## **Response to Further Information**

Laurclavagh Renewable  
Energy Development

1.1.1 MKO have been instructed by our client, Laurclavagh Limited, (the Applicant) to prepare this report in response to a Further Information Request (FIR) issued by An Coimisiún Pleanála (ACP Pl. 319307-24) on 5<sup>th</sup> March 2025. The Response to Further Information (RFI) is being made regarding a proposed renewable energy development which will comprise 8 no. wind turbines and associated infrastructure in the townland of Laurclavagh and adjacent townlands near Tuam, Co. Galway. The Applicant is seeking a 10-year planning permission and a 30-year operational life. This application was submitted on 15<sup>th</sup> March 2024 (ACP Pl. 319307). The application meets the threshold for wind energy set out in the Seventh Schedule of the Planning and Development Act 2000, as amended, on foot of a notice issued by An Coimisiún Pleanála and was therefore submitted directly to An Coimisiún Pleanála as a Strategic Infrastructure Development (SID) in accordance with Section 37E of the Planning and Development Act as amended.

PROJECT TITLE:			
Laurclavagh Renewable Energy Development, Co. Galway			
DRAWING TITLE:			
Proposed access junction off the L-61461			
PROJECT No.:	DRAWING No.:	SCALE:	
210627	210626 - 39	1:1,000 @ A3	
DRAWN BY:	CHECKED BY:	DATE:	REVISION.:
JOB	TH	13.03.2024	P01

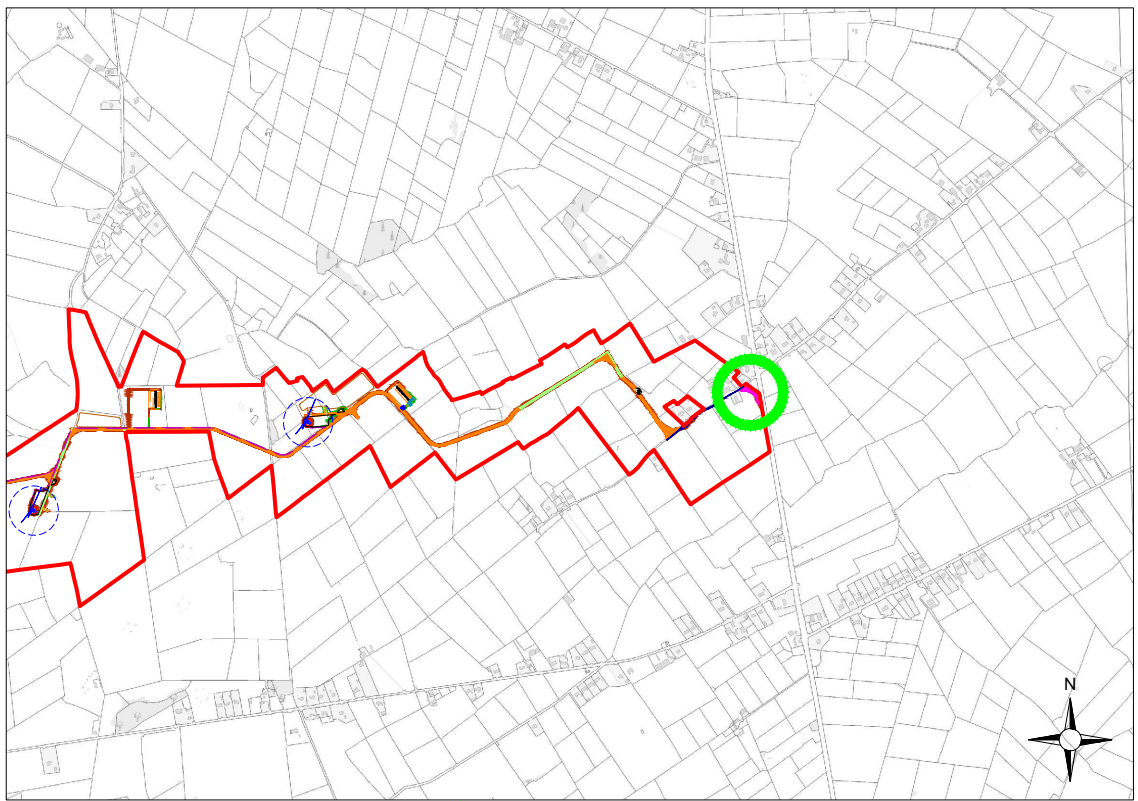
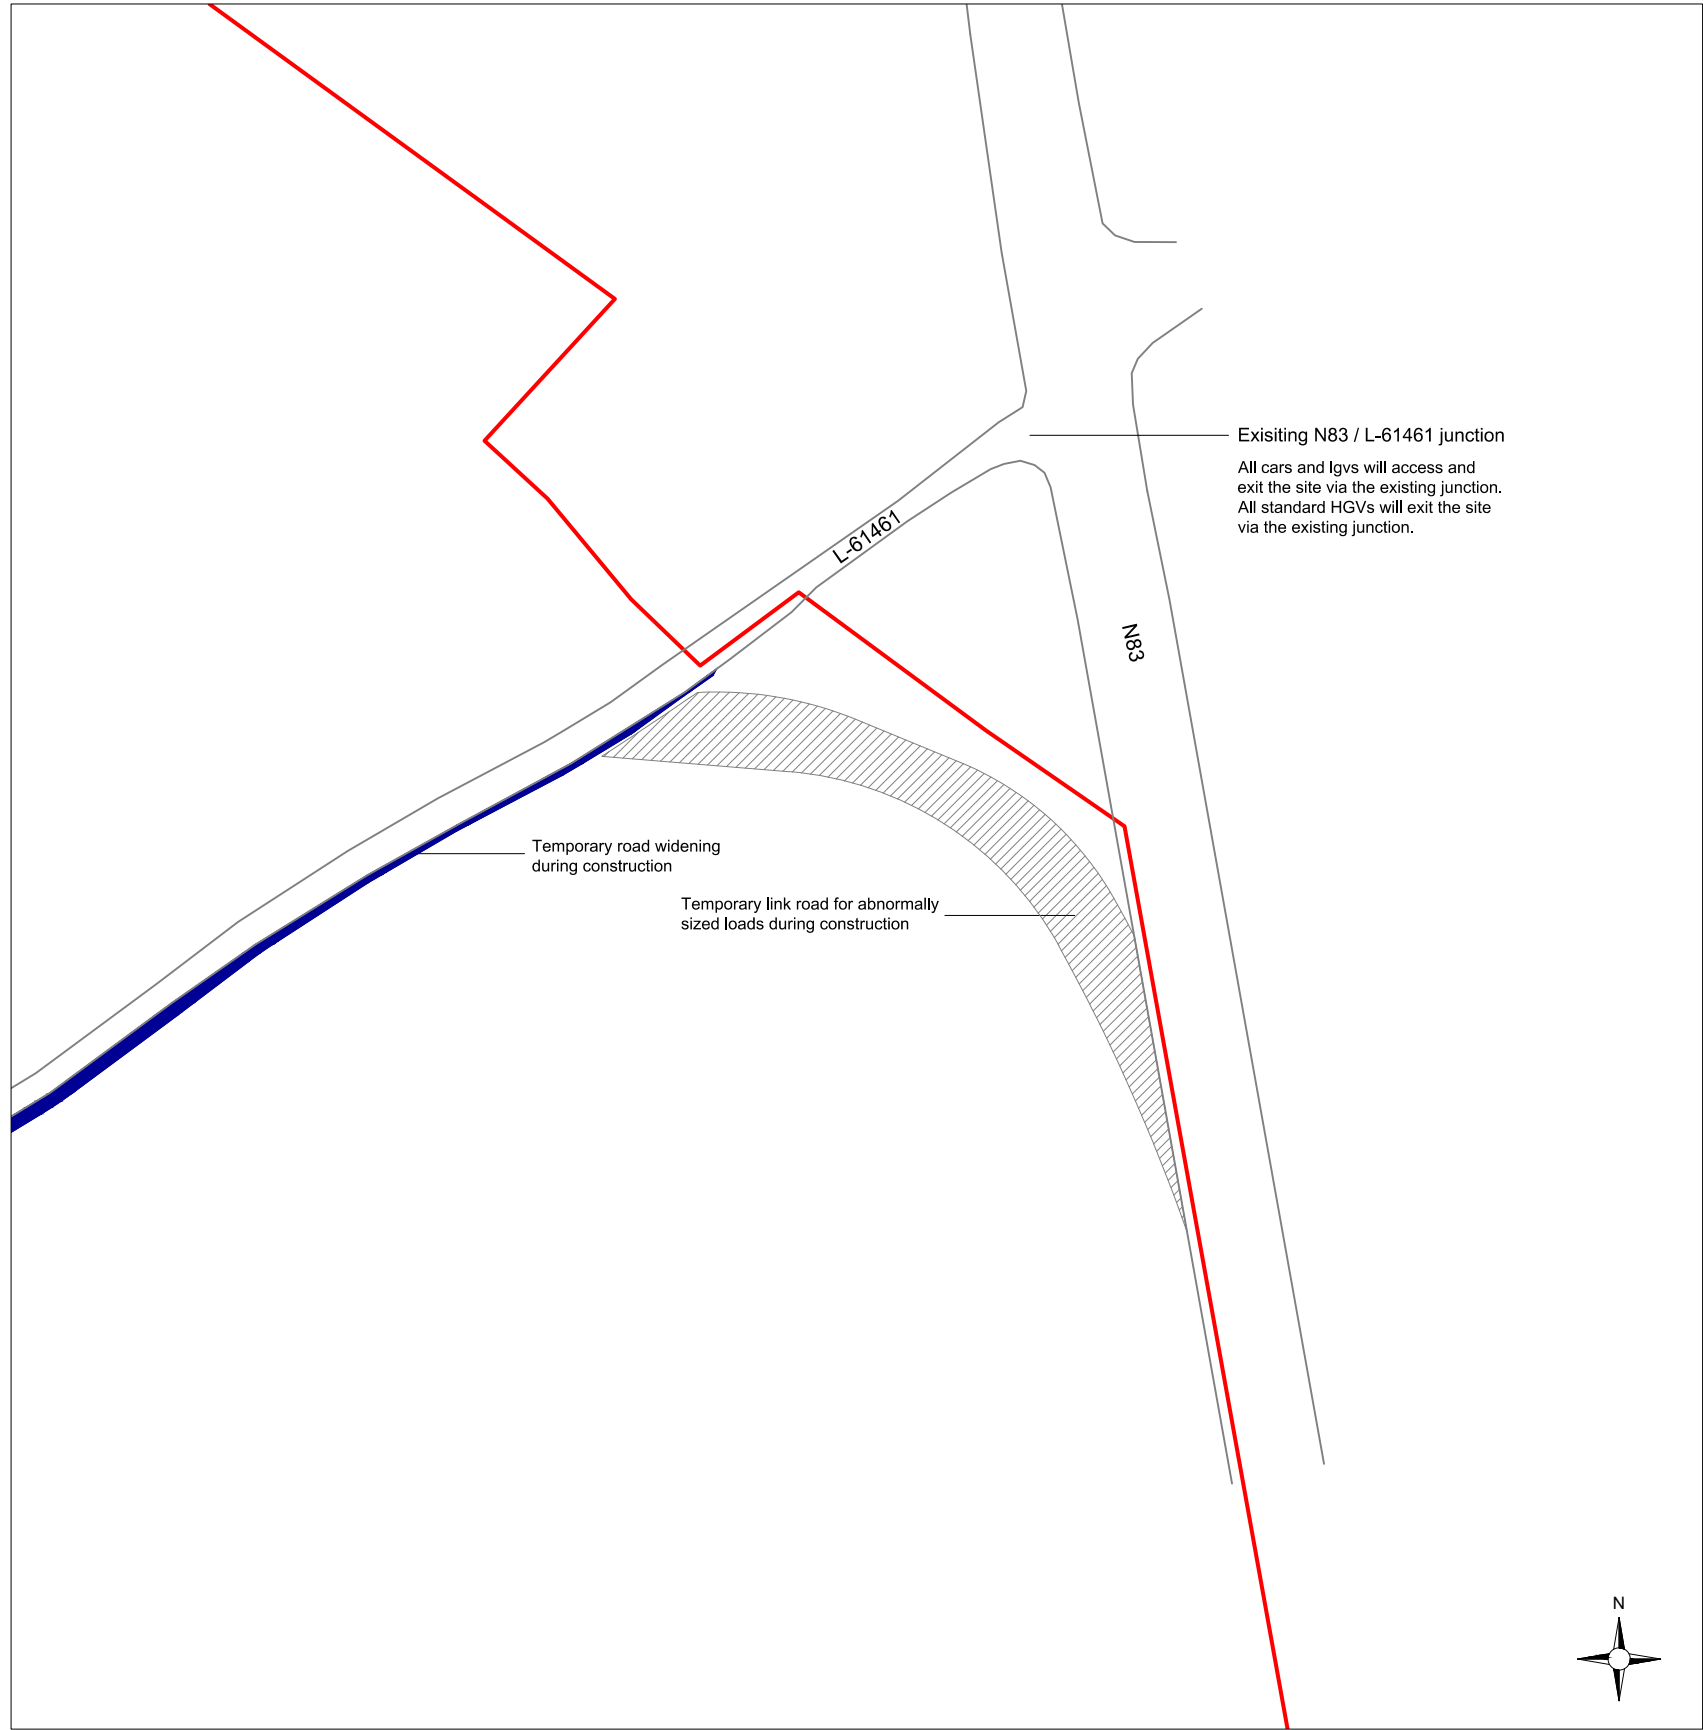
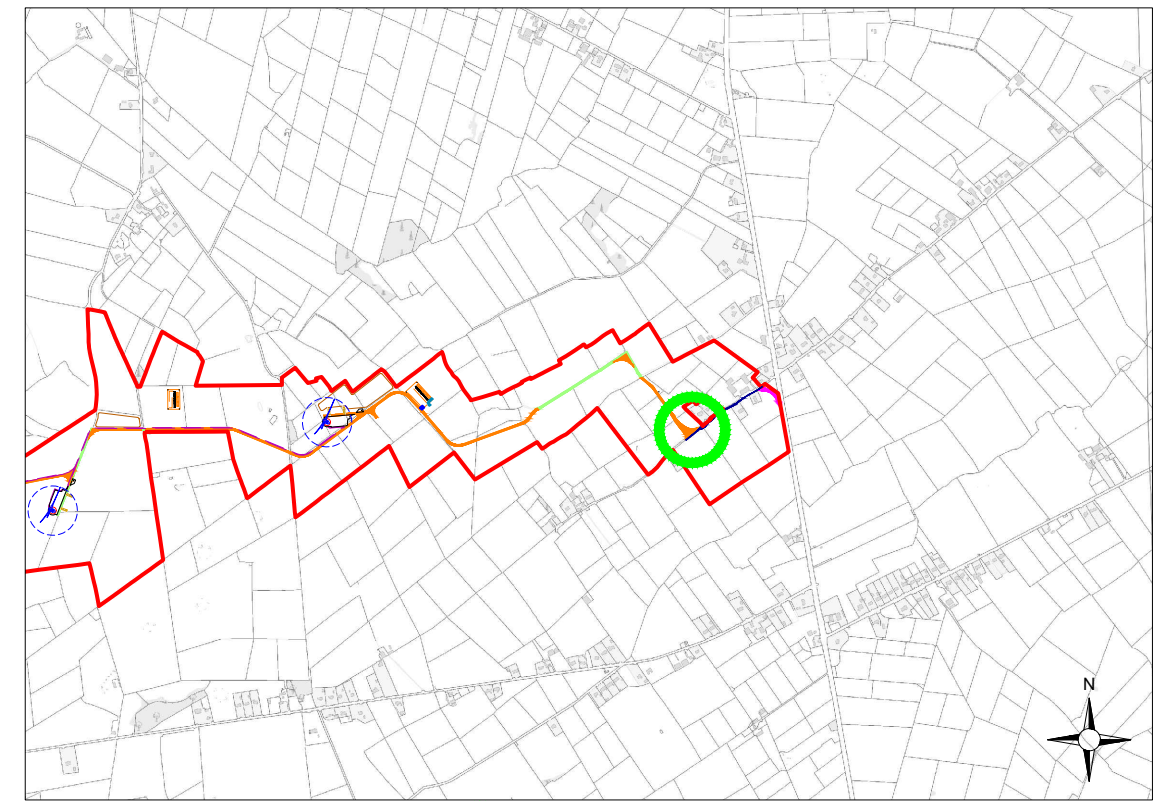
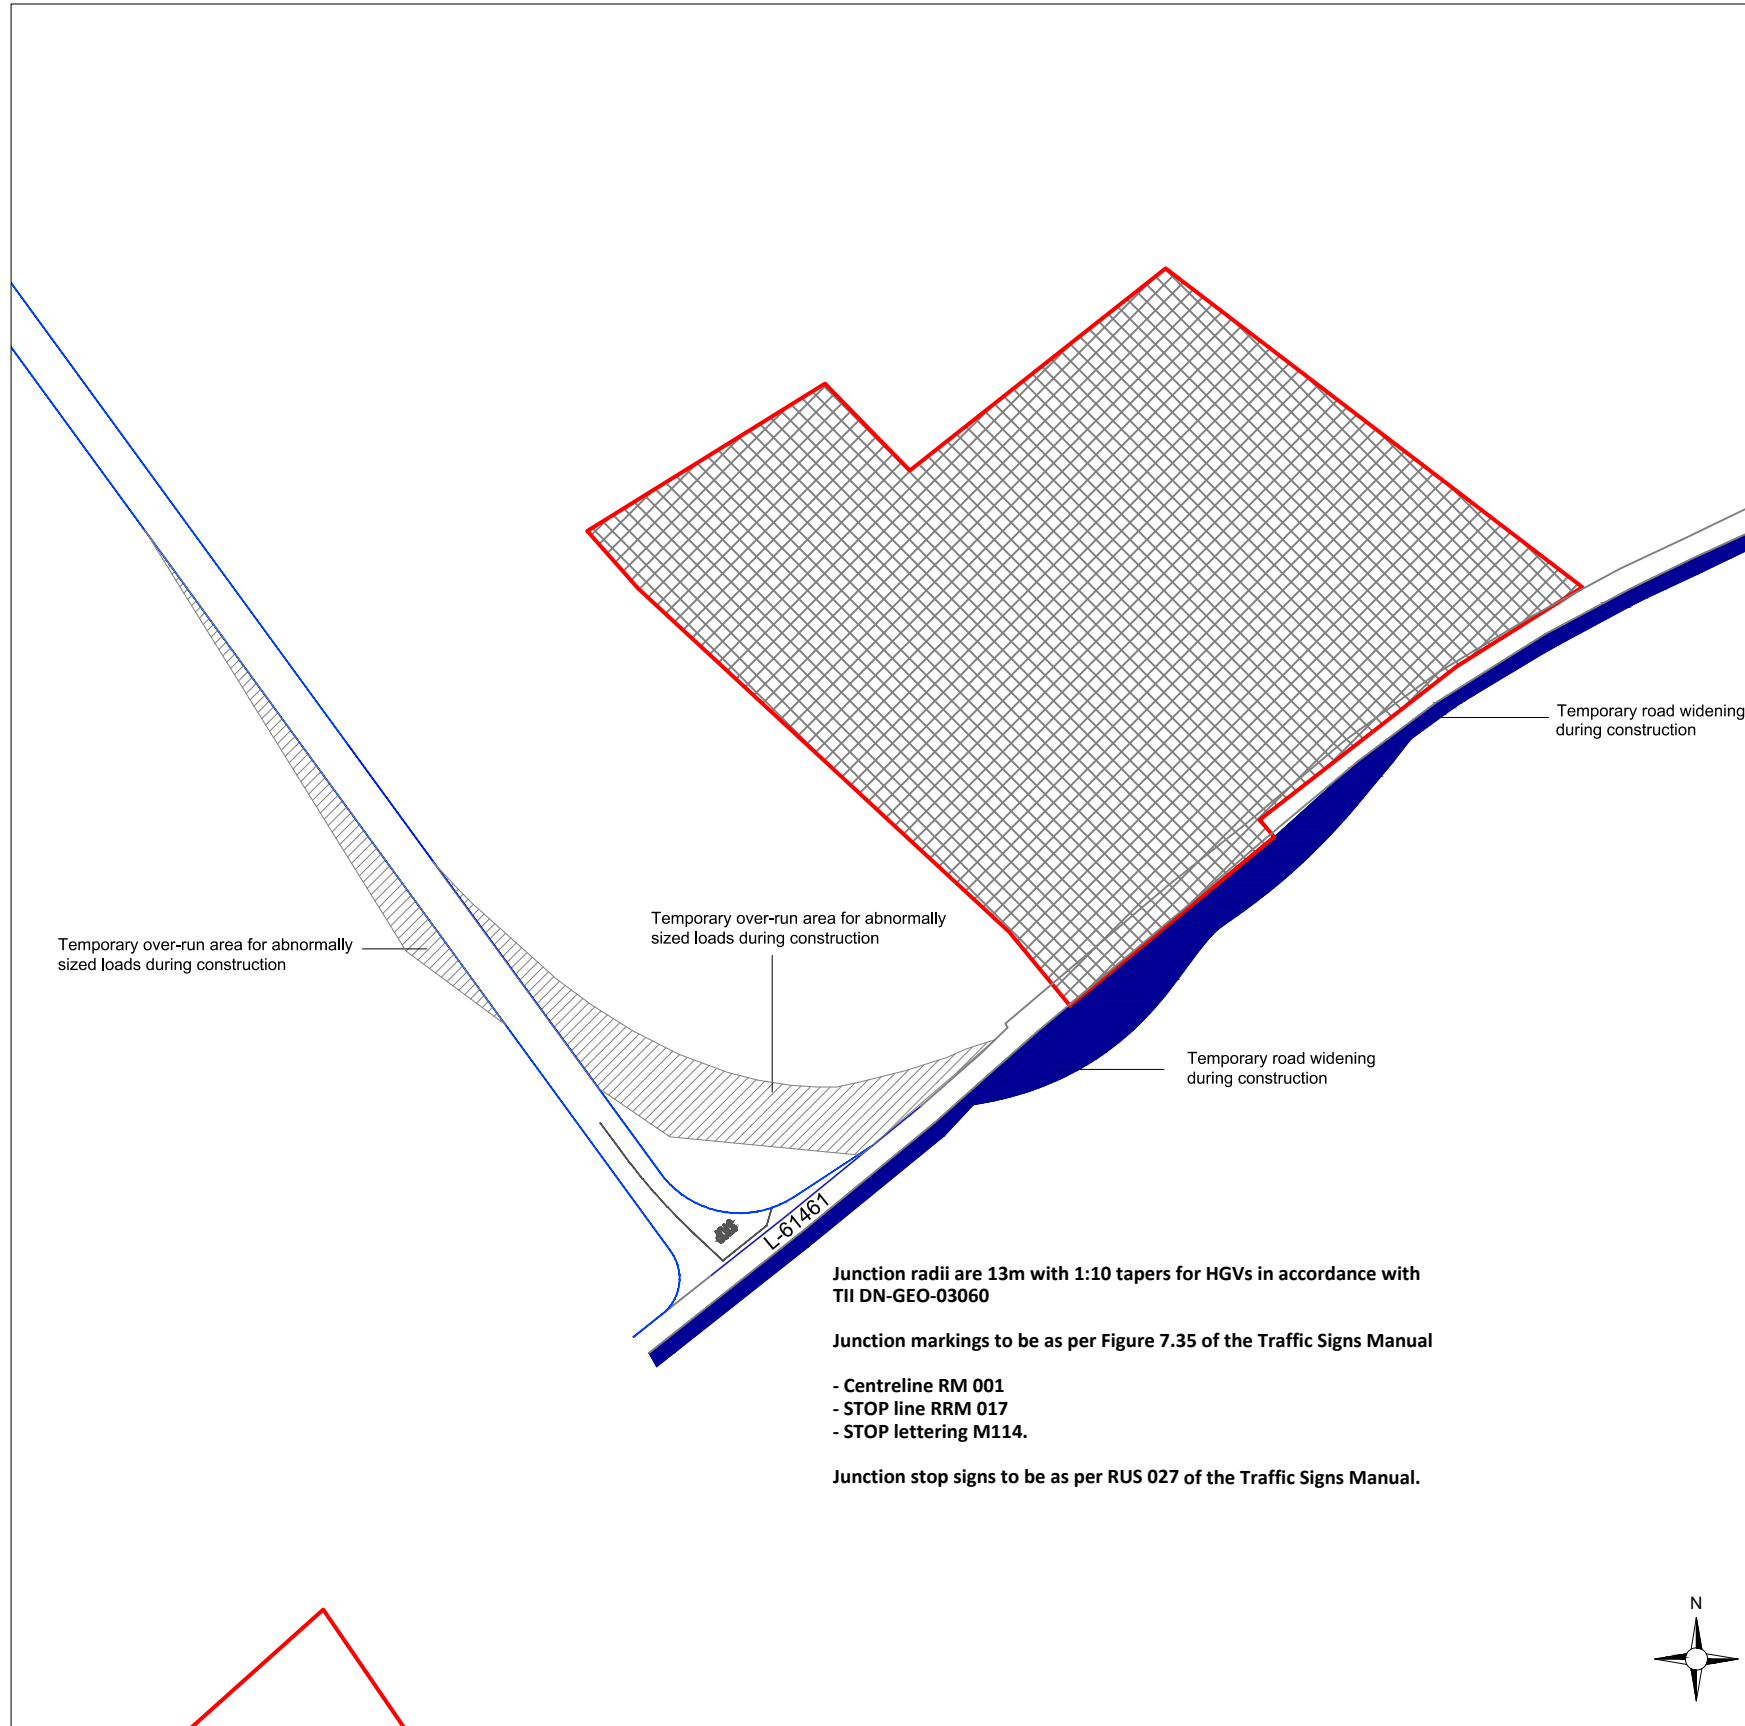
| Further Information Item No.            | Query                                                                                                                                                                                                                                                                                                                                                                                                                                                                                                                                                         | Response to Further Information                                                                                                                                                                                                                                                                                                                                                                                                                                                                                                                                                                                                                                                                                                                                                                                                                                                                                                                                                                                                                                                                                                                                                                                                                                                                                                                                                                                                                                                                                                                                                                                                                                                                                                                                                                                                                                                                                                                                                                                                                                                                                            |
|-----------------------------------------|---------------------------------------------------------------------------------------------------------------------------------------------------------------------------------------------------------------------------------------------------------------------------------------------------------------------------------------------------------------------------------------------------------------------------------------------------------------------------------------------------------------------------------------------------------------|----------------------------------------------------------------------------------------------------------------------------------------------------------------------------------------------------------------------------------------------------------------------------------------------------------------------------------------------------------------------------------------------------------------------------------------------------------------------------------------------------------------------------------------------------------------------------------------------------------------------------------------------------------------------------------------------------------------------------------------------------------------------------------------------------------------------------------------------------------------------------------------------------------------------------------------------------------------------------------------------------------------------------------------------------------------------------------------------------------------------------------------------------------------------------------------------------------------------------------------------------------------------------------------------------------------------------------------------------------------------------------------------------------------------------------------------------------------------------------------------------------------------------------------------------------------------------------------------------------------------------------------------------------------------------------------------------------------------------------------------------------------------------------------------------------------------------------------------------------------------------------------------------------------------------------------------------------------------------------------------------------------------------------------------------------------------------------------------------------------------------|
| 1.1                                     | <p><i>The N83-L61461 junction layout as outlined in submitted plans, the traffic management plan and in your response to submissions do not appear to be consistent with the existing onsite arrangement. The existing junction layout appears to display restricted sightlines in both northerly and southerly directions onto the N83. Given the application details submitted to date and the existing junction layout, consultation should take place with the planning authority in order to clarify the status of the existing junction layout.</i></p> | <p>In agreement with the Commissions observations, it is noted that the road markings on the L61461 minor arm approach to the junction with the N83 have changed in the interim period from when the EIAR was prepared up to the point when the submissions were being responded to. It is considered that the 2 different layouts have little impact on the Proposed Project. As stated in the EIAR, temporary traffic management measures are proposed at this location as mitigation during the critical construction period. A description of the 2 junction configurations is as follows;</p> <p>Layout 1 - In place during the preparation of the EIAR - Stop line extended to carriageway edge to maximise visibility splays for traffic accessing the N83.</p> <p>This configuration is as described in the EIAR, and in the Response to Observations Received Report, with the relevant information now included in the EIAR Addendum.</p> <p>The layout is provided in Appendix 2 Addendum Planning Drawings of this RFI is shown in plan in Figure FI1 in Appendix 15-5 of the Report, with the key points to note for this layout as follows.</p> <ul style="list-style-type: none"> <li>➤ The hard shoulder is discontinued to the north of the junction by means of yellow hatching and to the south before the commencement of the left turn lane that provides access from the N83 onto the L61461.</li> <li>➤ This permits the STOP line to be located adjacent to the carriageway edge, as opposed to the nearside edge of the hard shoulder, and the x-distance for the visibility splays to be measured from the edge of carriageway, as is shown for this layout in Figure FI2 in Appendix 15-5 of the Report. As shown, for this arrangement the full 3m x 215m visibility splays, as are required for a 100 kph speed limit, are available (Reference Geometric Design of Junctions, DN-GEO-03060, TII, May 2023).</li> </ul> <p>It is noted that this junction layout with an extended stop line exists at various other junctions on the N83 in close proximity to the N83 / L61461 junction.</p> |
